CITY OF ALBUQUERQUE

RE: 9101 Central Ave NW

Grading and Drainage Plans Engineer's Stamp Date: 01/10/24

Hydrology File: K09D002

Sheet Title :
HYDROLOGY PLAN

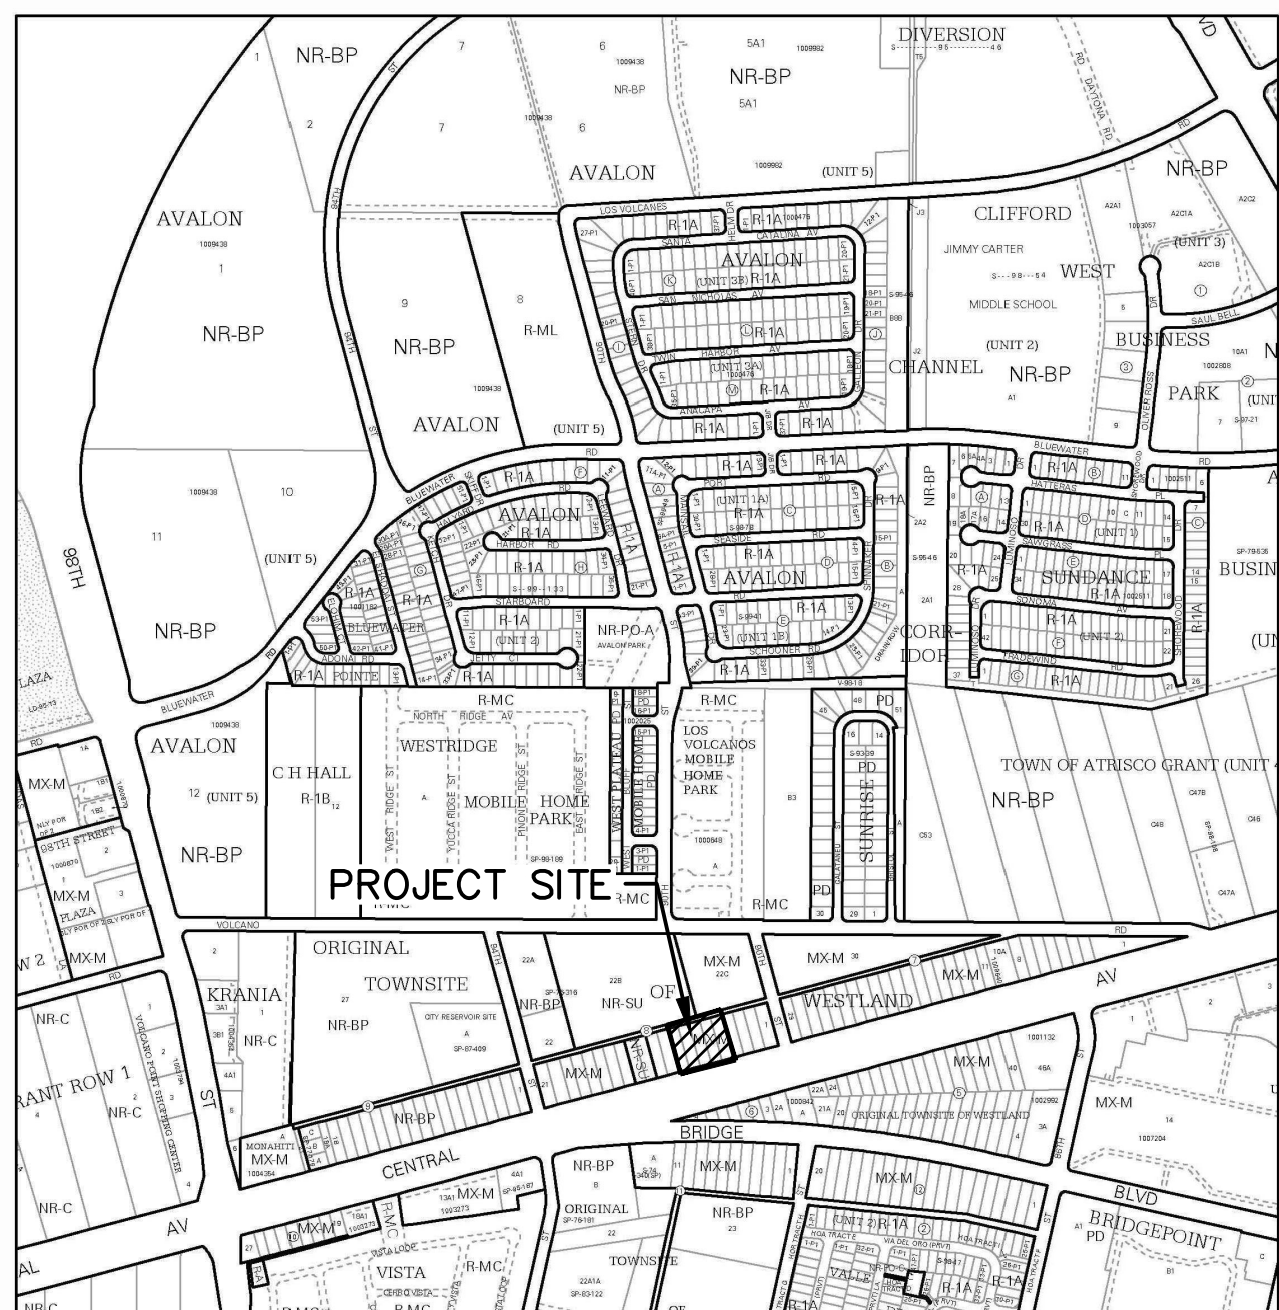
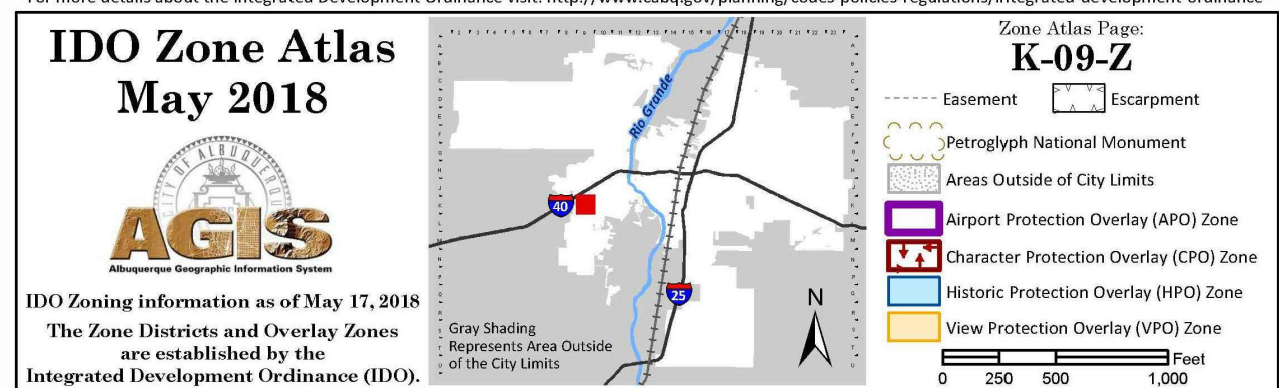
- 2. Please use the procedure for 40 acre and smaller basins as outlined in Development Process Manual (DPM) Article 6-2(a). Please provide both the existing conditions and proposed conditions for the 100 year-6 hour storm event.

- 3. Please follow the DPM Article 6-12 Stormwater Quality and Low-Impact Development for the sizing calculations. To calculate the required SWQV, multiply the impervious area (Square feet) draining to the BMP by 0.42 inches for new development sites divided by 12 to get the required volume in cubic feet. The calculations of both the required and the provided volume of each BMP must be shown on the Grading and Drainage Plan. Each BMP should be labeled on the Grading and Drainage Plan with the required SWQV and associated water surface elevation and the 100-year water surface elevation. Landscaping of surface BMPs is also required to be noted on the Grading and Drainage Plan.

- 4. Please provide a section of the SWQ Pond showing the water surface elevation (the SWQ volume), the retaining wall with footer, distance from the wall to the property line, label the Central Rd R.O.W., please show the spillway of the SWQ pond to the existing

- 5. I have seen the spillway as a gap in the wall, so if you do this, please show the detail of that section and provide the weir calculation for it. (see below)

- 6. Please provide the weir calculations, per DPM Article 6-16(A), for the curb cuts and sidewalk culverts. A coefficient of 2.7 is typically used for the weir equation $Q = CLH^{2/3}$.

- 8. Under the Existing Conditions, please state that this site is within the Amole-Hubbell Master Drainage Plan by Wilson (2013) and has a discharge rate of 4.11 cfs/ac.
